PLANNING AMENDMENT

APPLICANT NAME AND ADDRESS CANDICE DAVIDSON. 117 HIGH STREET. GOSBERTON. SPALDING. PEELINGNA Telephone: [REDACTED]		AGENT NAME AND ADDRESS REMWAY DESIGN. Telephone:	
SITE ADDRESS DETAILS 98 HIGH STREET. GOSBERTON. PEELINGNA			
CURRENT APPLICATION NO: This amendment cannot be considered unless the relevant reference is stated.		H08-0514-20	
Building Regulation reference relating to same development (if applicable)

**Site Location &
Block Plan**

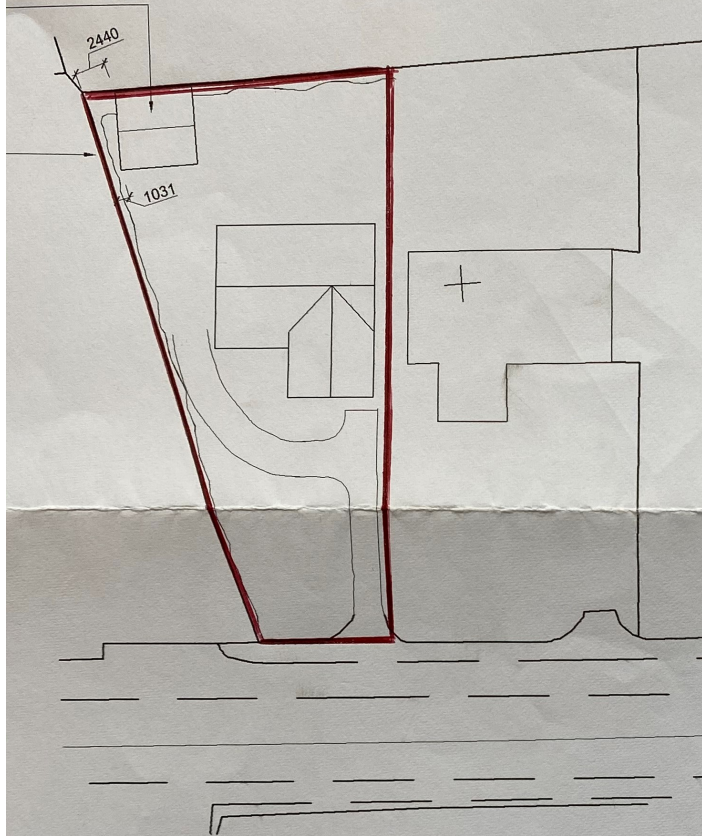
FULL DESCRIPTION OF DEVELOPMENT OF CURRENT APPLICATION THAT THIS AMENDMENT RELATES TO		GARAGES TO BE AT FRONT LEFT SIDE OF HOUSE. NOT NEEDING DRIVEWAY TO	
State details of amendments proposed. (Give a full detailed list of the changes, and also mark these clearly on the accompanying plans. Only the changes listed here will be considered)		LEFT OF HOUSE. HOUSE TO BE MOVED OVER TO LEFT WITH PATHWAY ON LEFT SIDE NOW.	
State drawing numbers of the current submission		1500-03 "C"	
Has this amendment been requested by the Council? (If so, state Officer dealing with the application)		YES/NO	
Describe any part of the original development which is excluded by virtue of the amendment, and state any alteration to plot numbers			
Has a similar amendment been submitted under Building Regulations? (If so, state Building Control Surveyor dealing with application)		YES/NO
